From: Chris Bembridge <Chris.Bembridge@kirklees.gov.uk>
Sent: 09 April 2025 15:49
To: Danielle Cooper <Danielle.Cooper@kirklees.gov.uk>
Cc: Highways DevelopmentControl <Highways.DevelopmentControl@kirklees.gov.uk>
Subject: FW: 24/93594 Hollinghurst Farm, Honley

I've consulted Kirklees Highway Safety about this site and they have requested an independent Stage 1 Road Safety Audit (RSA) is completed for this site prior to determination (this is just on case the results of the RSA indicate the red-line boundary may need amending to allow for highway safety mitigation or visibility splays).

DRAWING DESCRIPTION
PROPOSED SITE PLAN
LONG SECTION

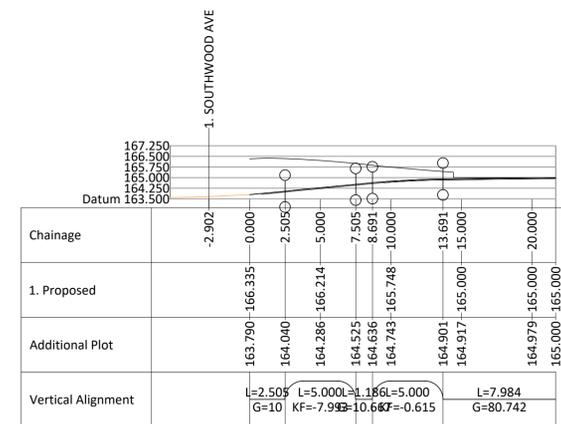
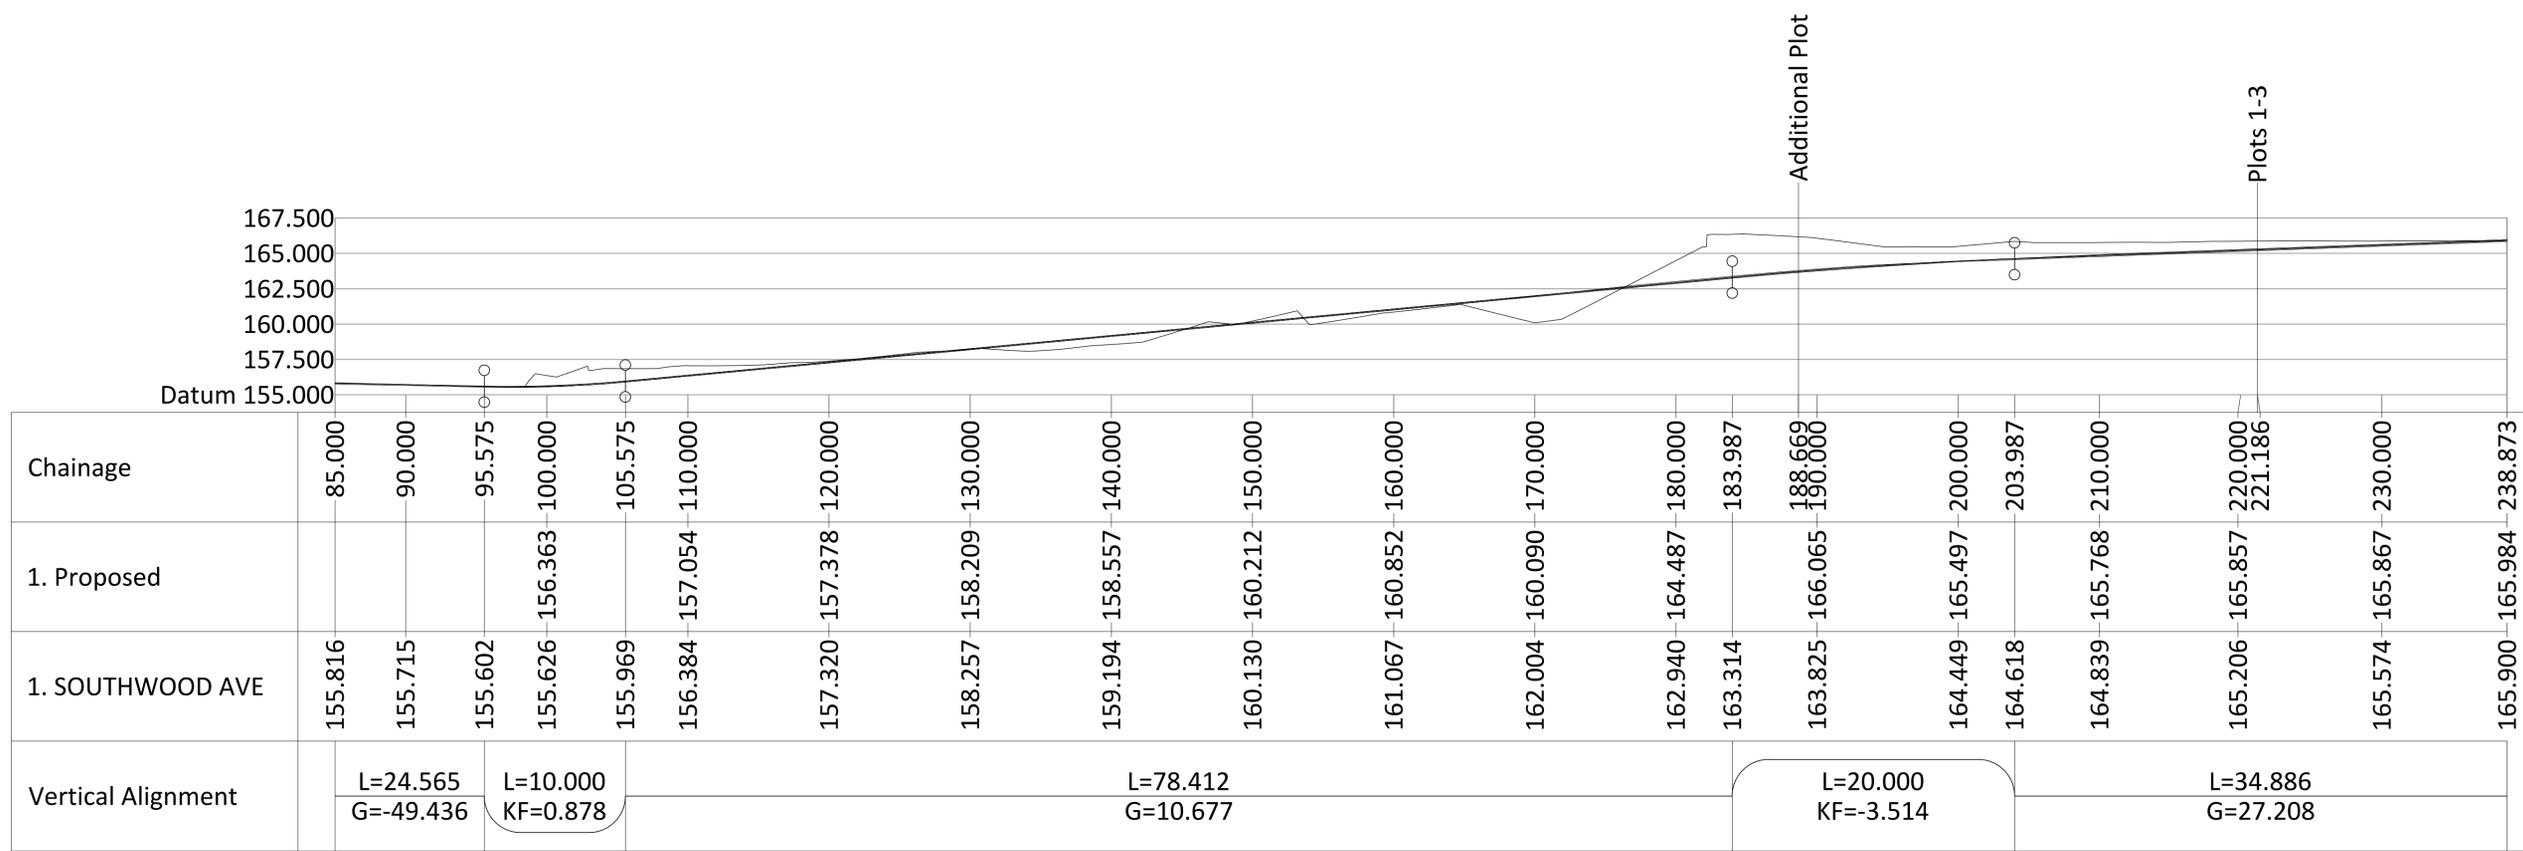
The Long Section indicates a gradient in excess of 10% which is too steep and above our criteria of a maximum of an 8% gradient and therefore this will need to be amended.

Given the vertical alignment is going to be steeper than the maximum 5% footways will be required on both sides of the carriageway.

DRAWING DESCRIPTION
 PROPOSED SITE PLAN
 preliminary issue OPTION 1

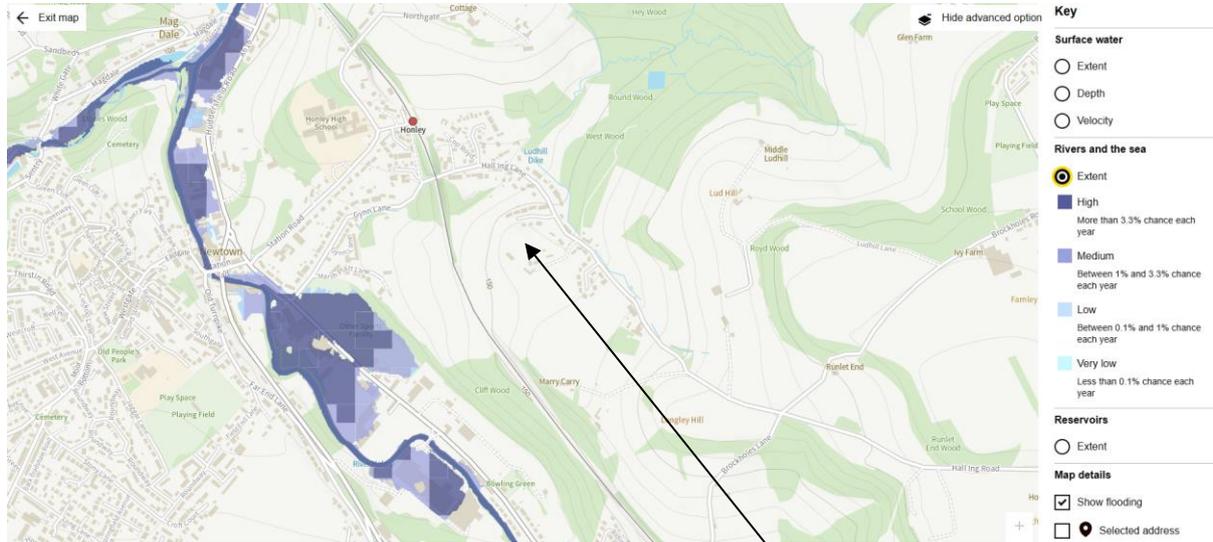
There are no visibility splays indicated. Junction and Forward Visibility Splays and dimensions must be in accordance with the Kirklees Design Guide (Table 1) and dedicated to Kirklees if they fall out of the existing highway boundary. Please provide the forward visibility splay around the bend.

A minimum carriageway width of 5.5m will be required.

Kirklees require a swept path drawing does not indicate how a refuge vehicle can pass an on-coming car and therefore this will needed to be widened around the bend to enable this manoeuvre. The turning manoeuvre at the end is also too tight and we will expect a minimum 0.5m clearance within the limits of the highway.

Only visitor parking bays parallel to the carriageway will be adopted. These must be a minimum of 2.5m x 6m. Any other bays (echelon or perpendicular) or private bays will not be considered for adoption. Where parallel parking bays are adjacent Public Open Space or walls please ensure if

there is no footway i.e. shared surface carriageway then there is a minimum 1-metre-wide hardstanding to enable safe entry and exit of the occupants.

No property including balconies should be within 500mm to the proposed highway. No doors, gates, windows, garage doors or gas/electric cupboards must open over the proposed highway.
